PLANNING CONSULTATION RESPONSE

Application No	2026/0503
Proposal	Erection of single storey office building (Use Class E(g)) with ancillary attached garage/store, external storage/open storage yard, formation of parking area and erection of wall/boundary treatments.
Address	Plot 9 Unit 1, Claycliffe Road, Barugh, Barnsley, S75 1HS
Date of Consultation Reply	18 th August 2026
Consultee	Highways DC

[3rd response]

SITE PLAN
SCALE 1:200

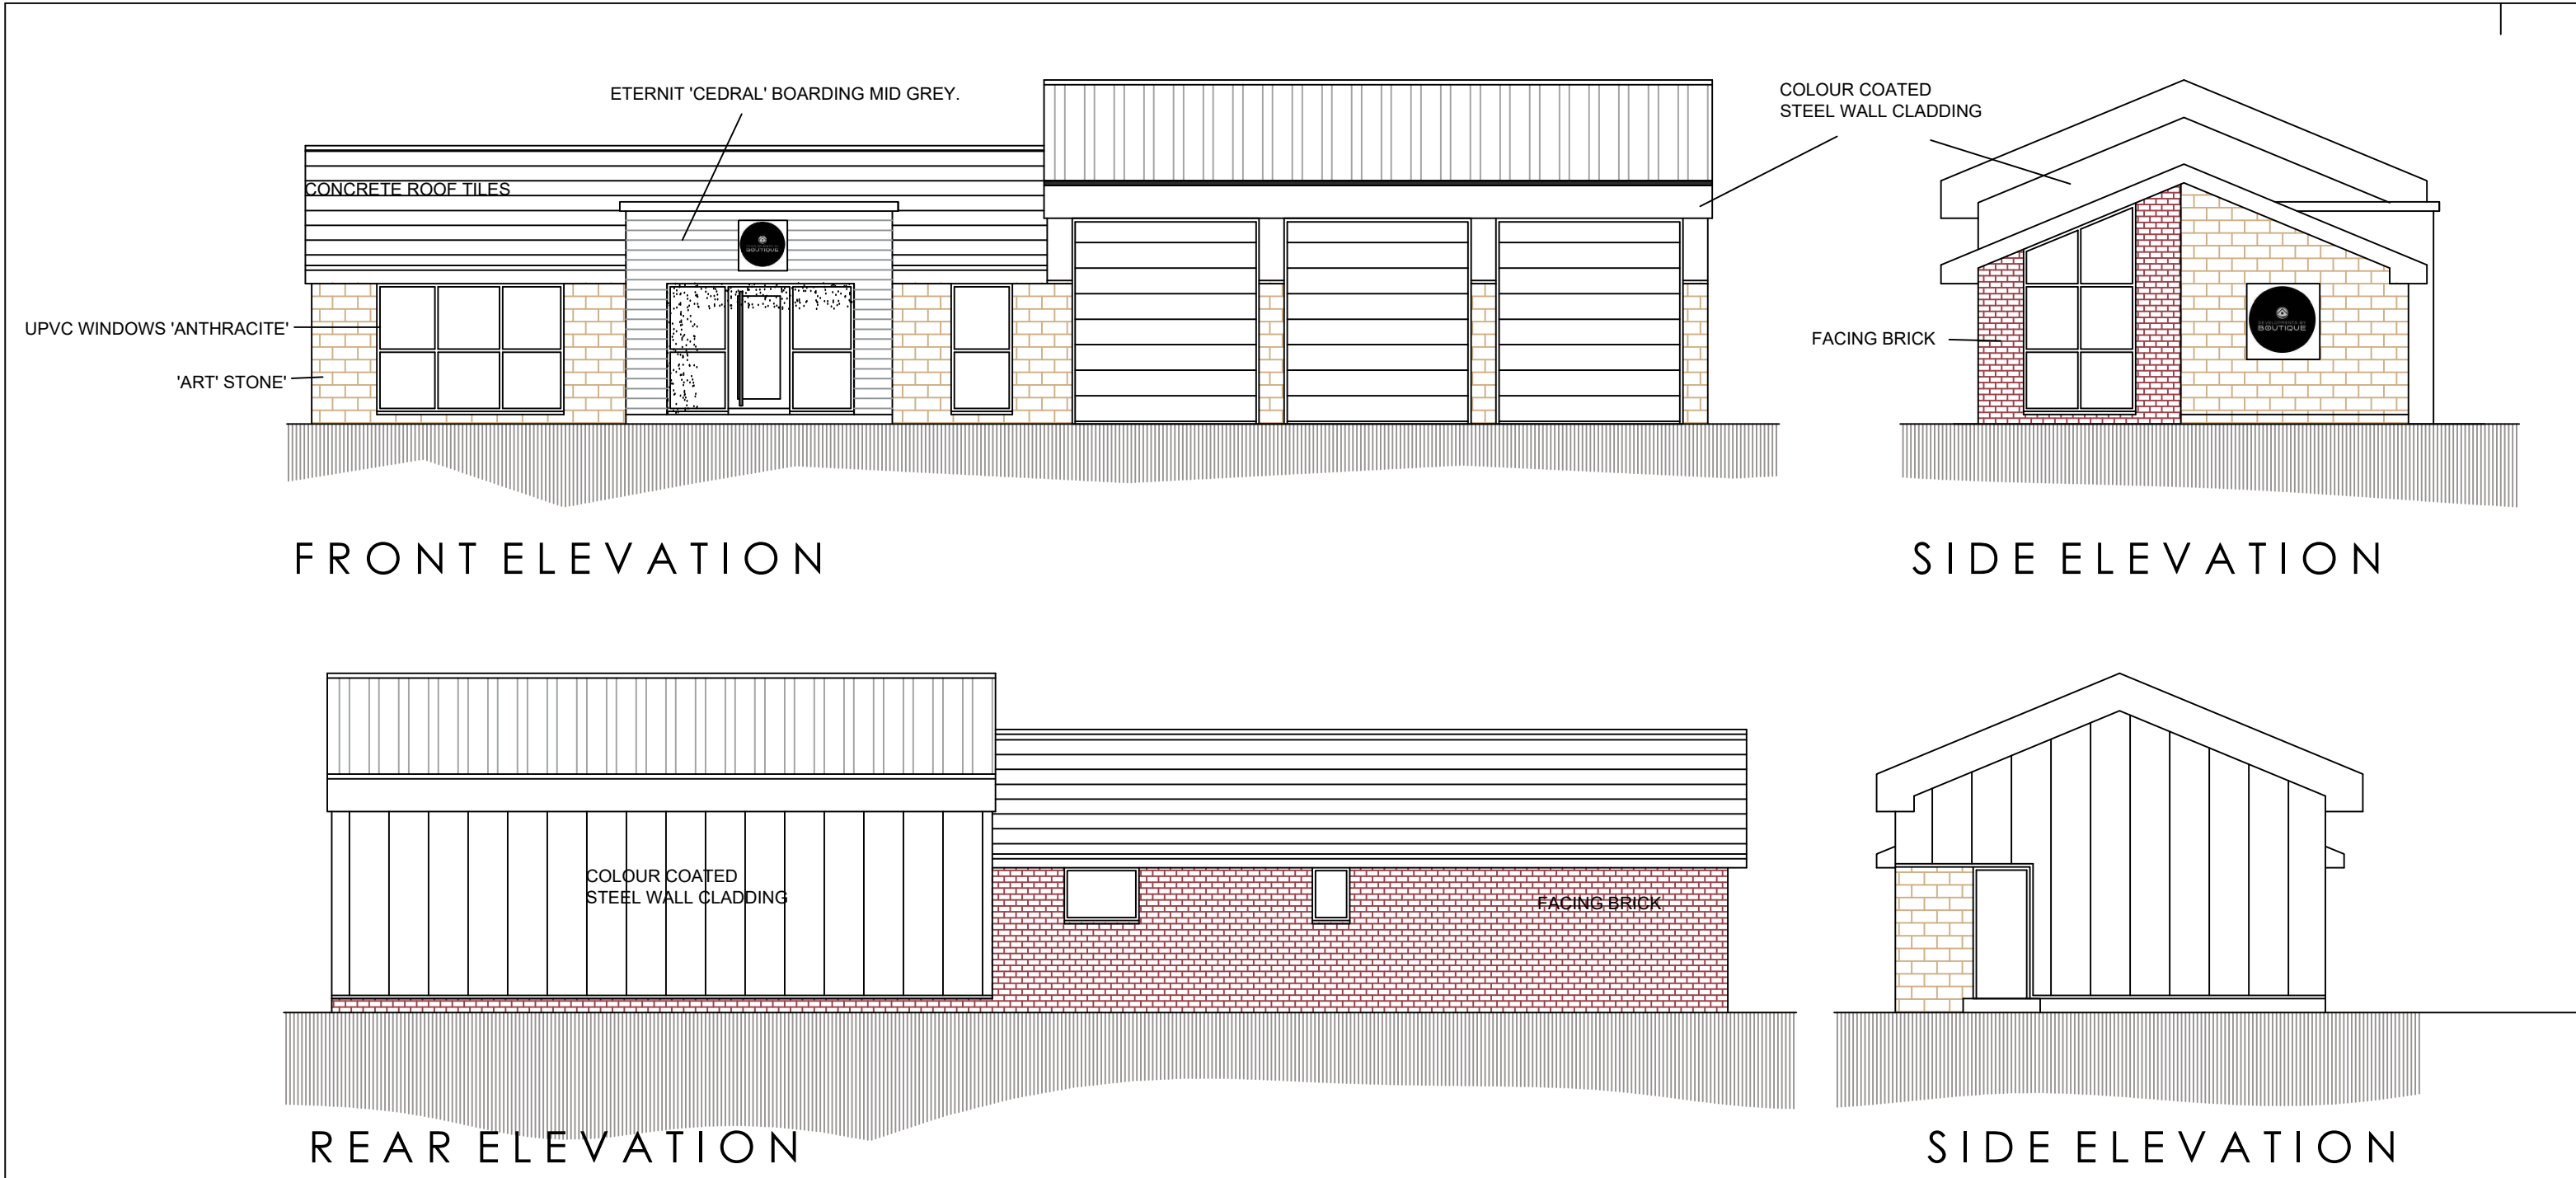
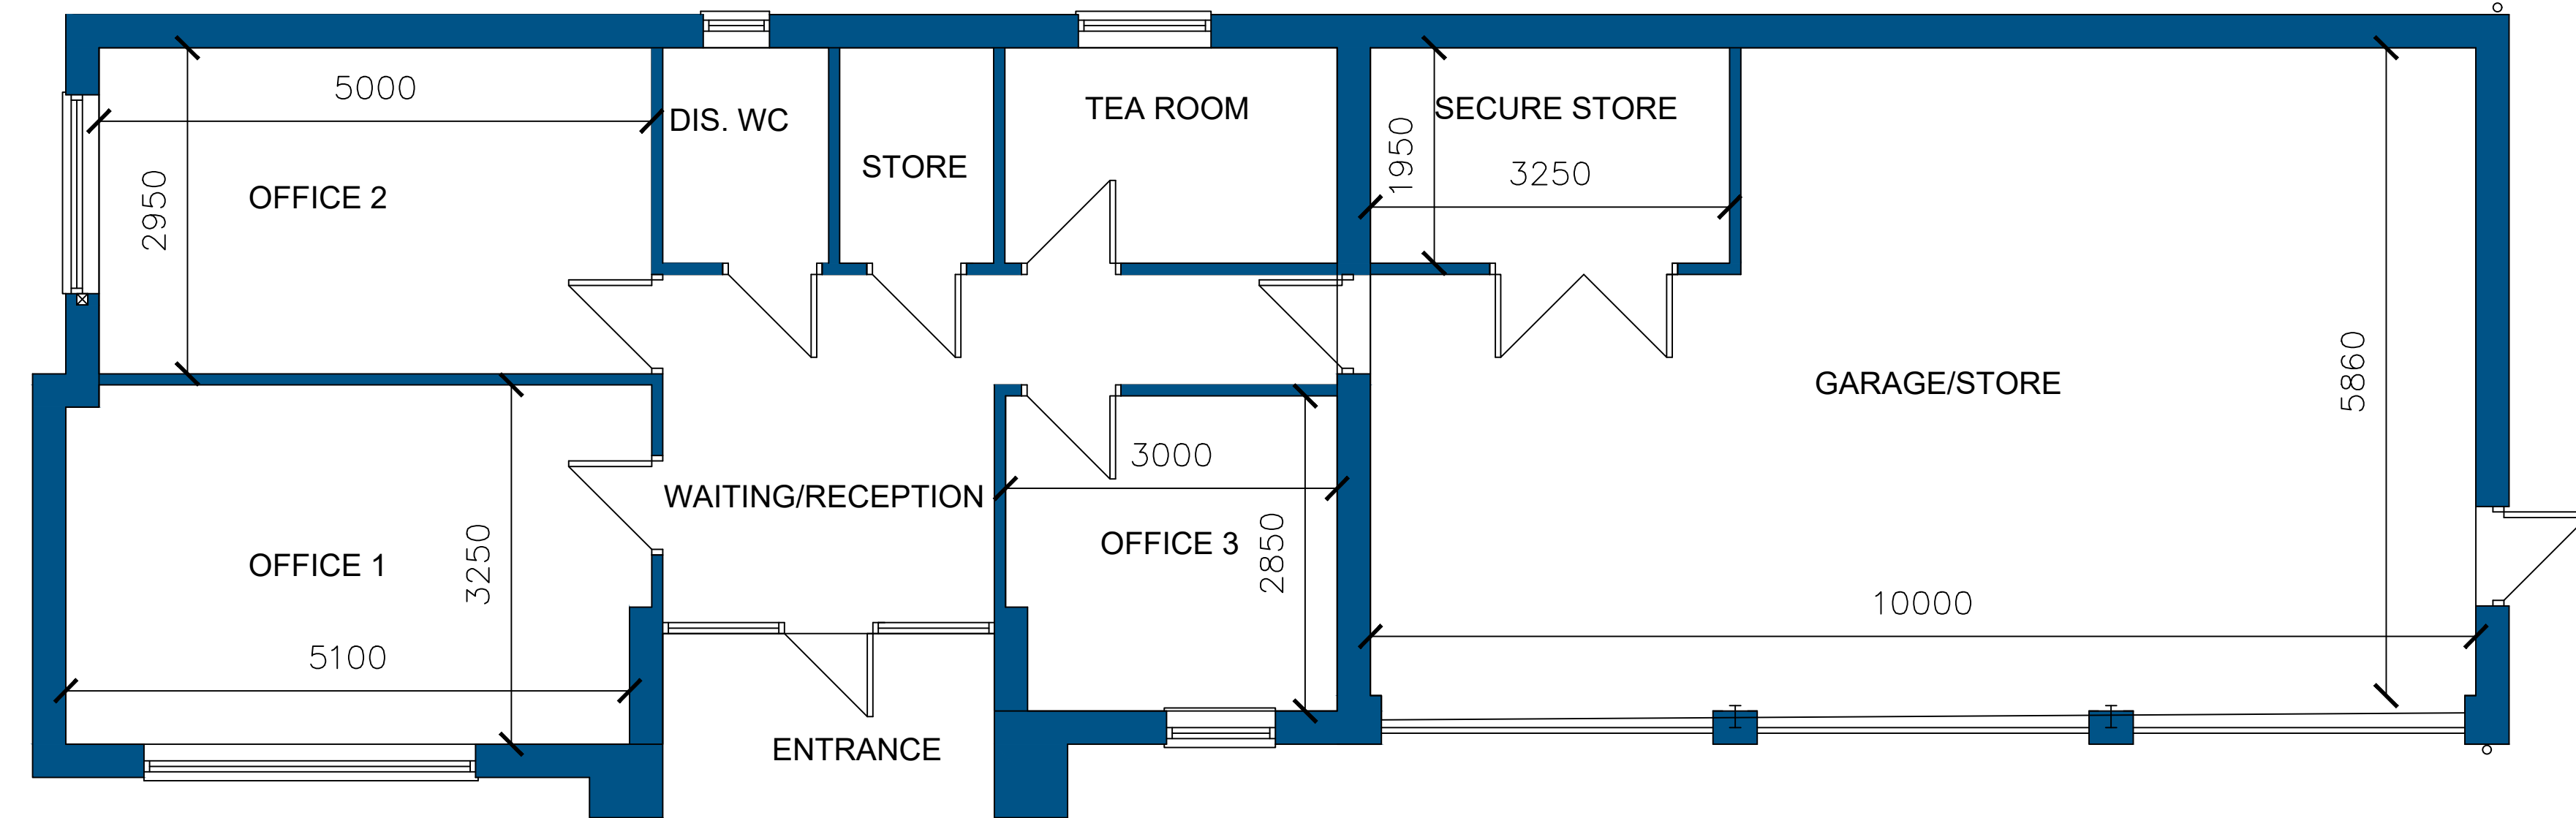
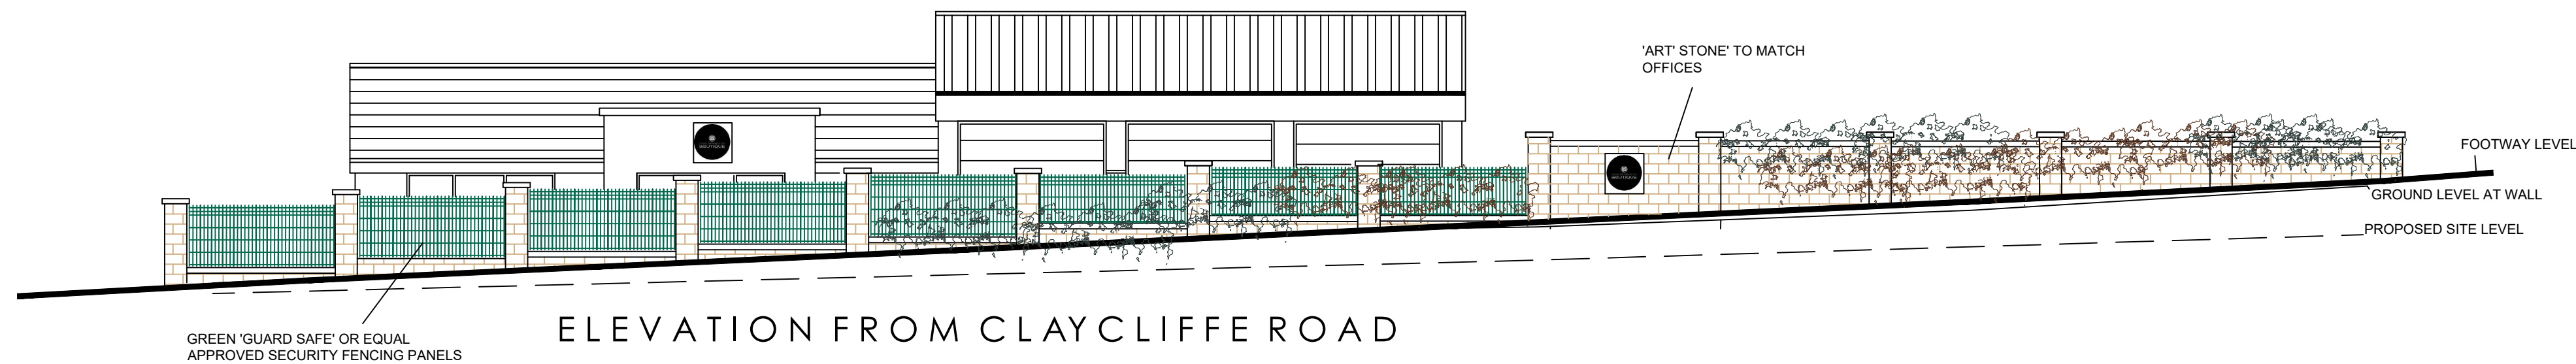
The revised Construction Method Statement (CMS) now includes details with regard to the location of suitable on-street parking areas for site operatives if required. Due to the A637 Claycliffe Road being unsuitable for on-street parking, the CMS has identified Whaley Road as being a suitable location; at a distance of approx. 250m from the site, it is stated that this is within easy walking distance.

The CMS also states that all vehicles will be inspected and have any mud washed off before being driven onto the public highway.

As such, the proposals are now considered acceptable from a highways development control perspective. Should you be minded to grant permission, I would be grateful if you could include the conditions and informative notes below.
